From: Charlotte Easton
Sent: 08 February 2019 10:42
To: [REDACTED]
Subject: Land adj 1 Holkham Cottage, Burndell Road, Yapton

I write to you regarding Land adjacent to 1 Holkham Cottage, Burndell Road, Yapton – reference Y/5/19/DOC.

Proposed Elevation

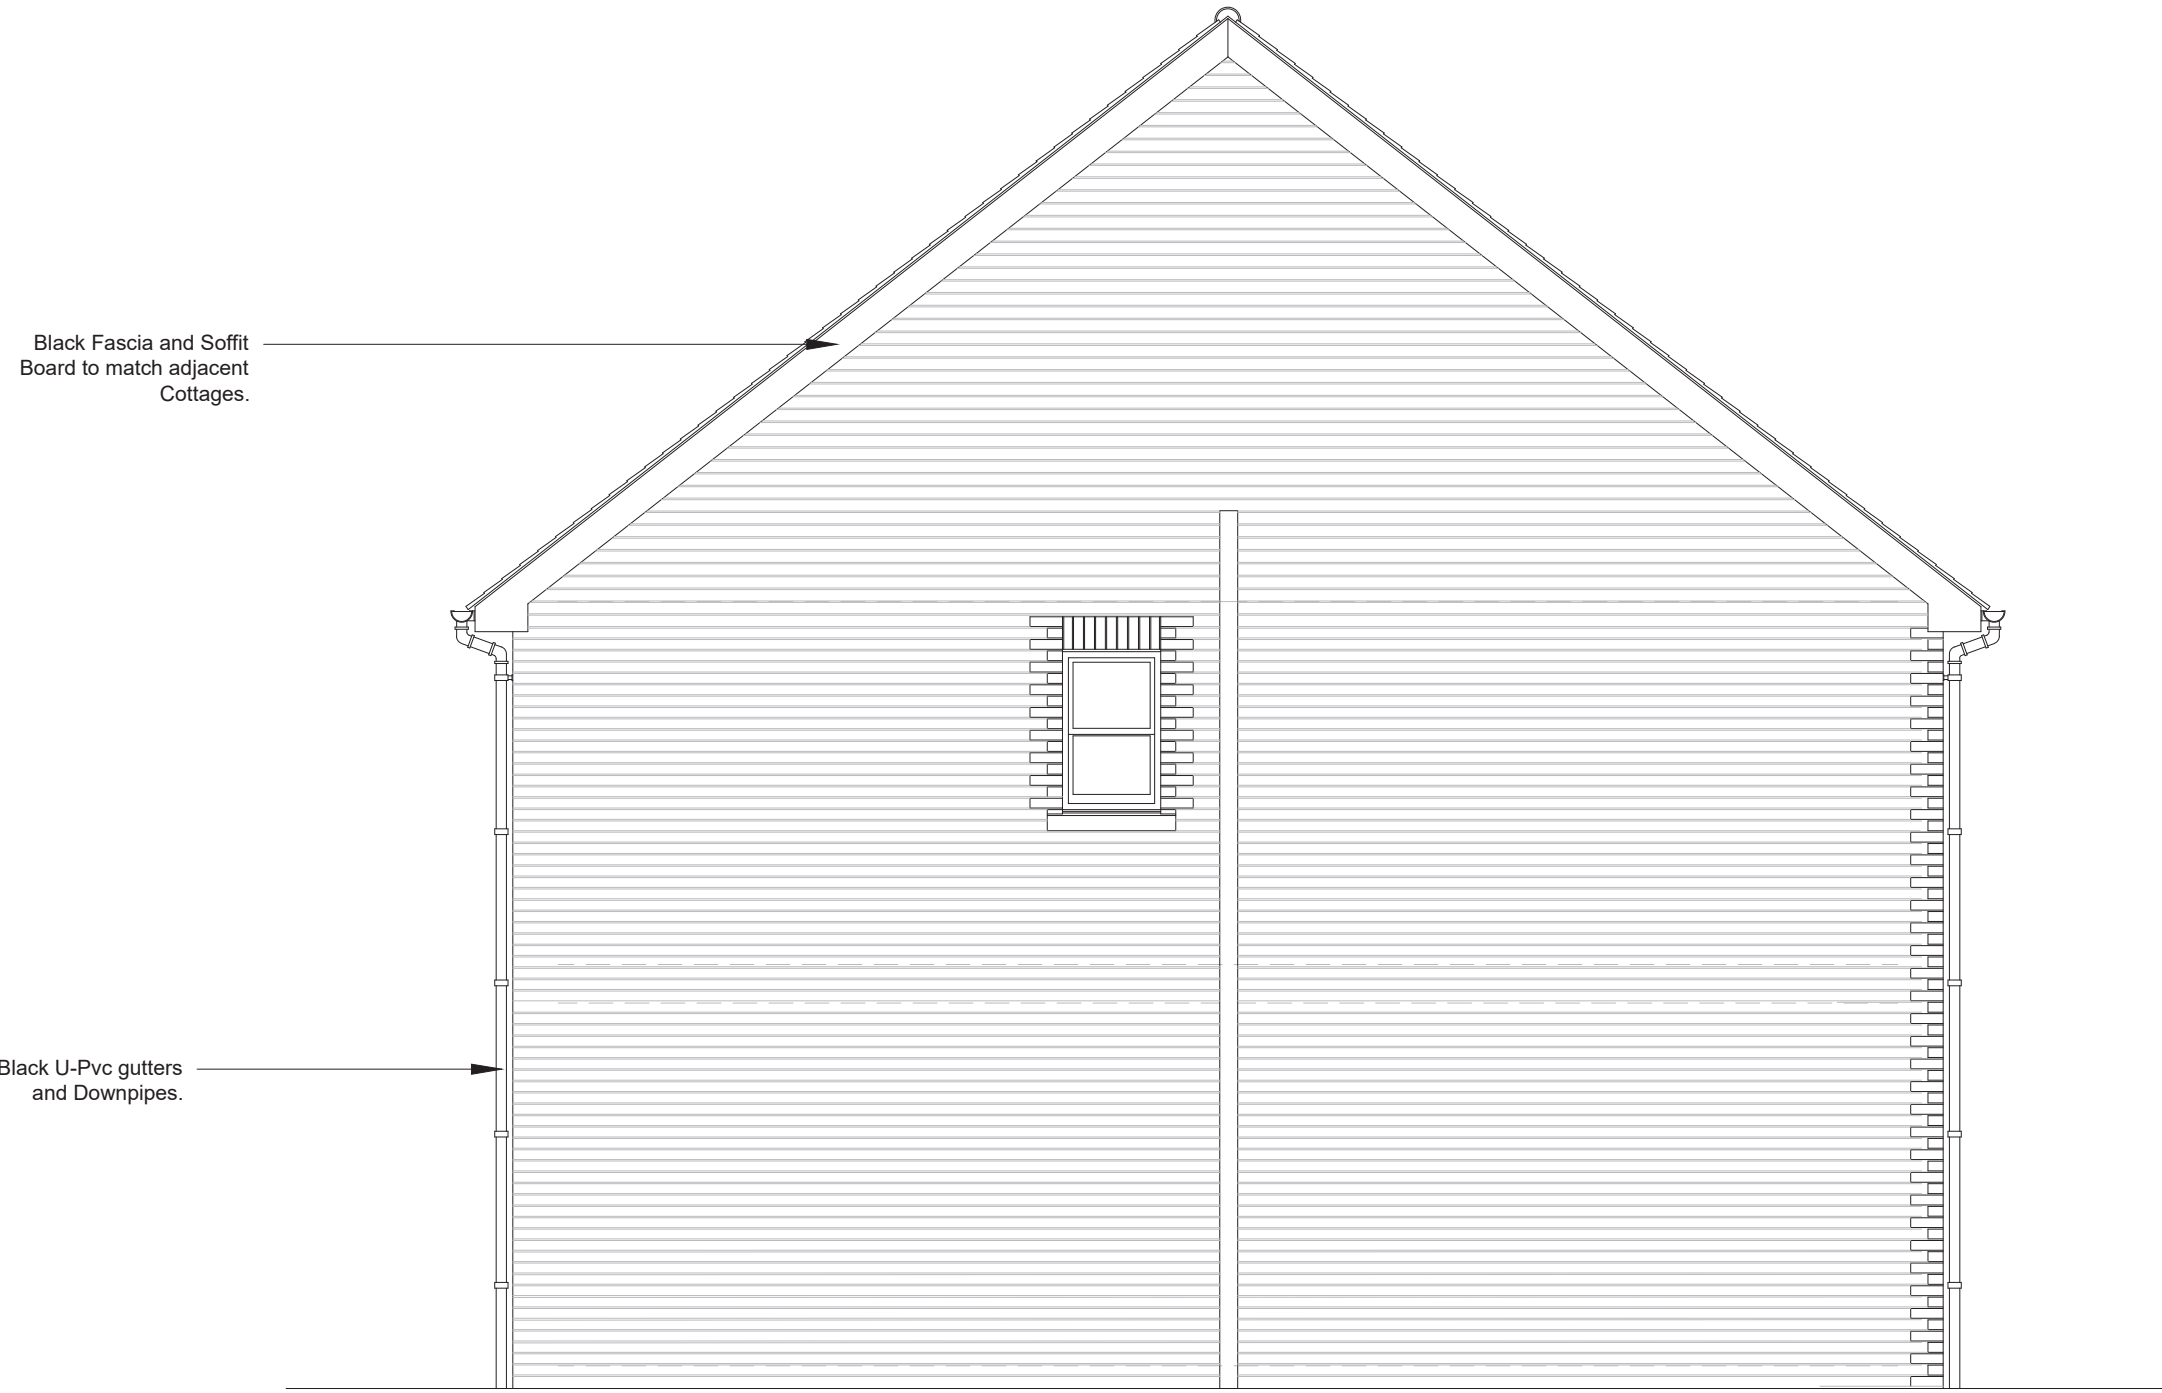
You should have received confirmation of the agreement to discharge condition 3 of planning application Y/47/18/PL, whilst looking at the drawings we have noticed there appears to be a slight difference to the approved plans of Y/47/18/PL and the Proposed elevations included within the DOC application. These appear to be the detailing around the windows and 'edges' of the dwellings, Y47/18/PL elevations indicate arches over the window however the revised drawing show a flat border almost.

We would advise that these can be dealt with through a Non material amendment.
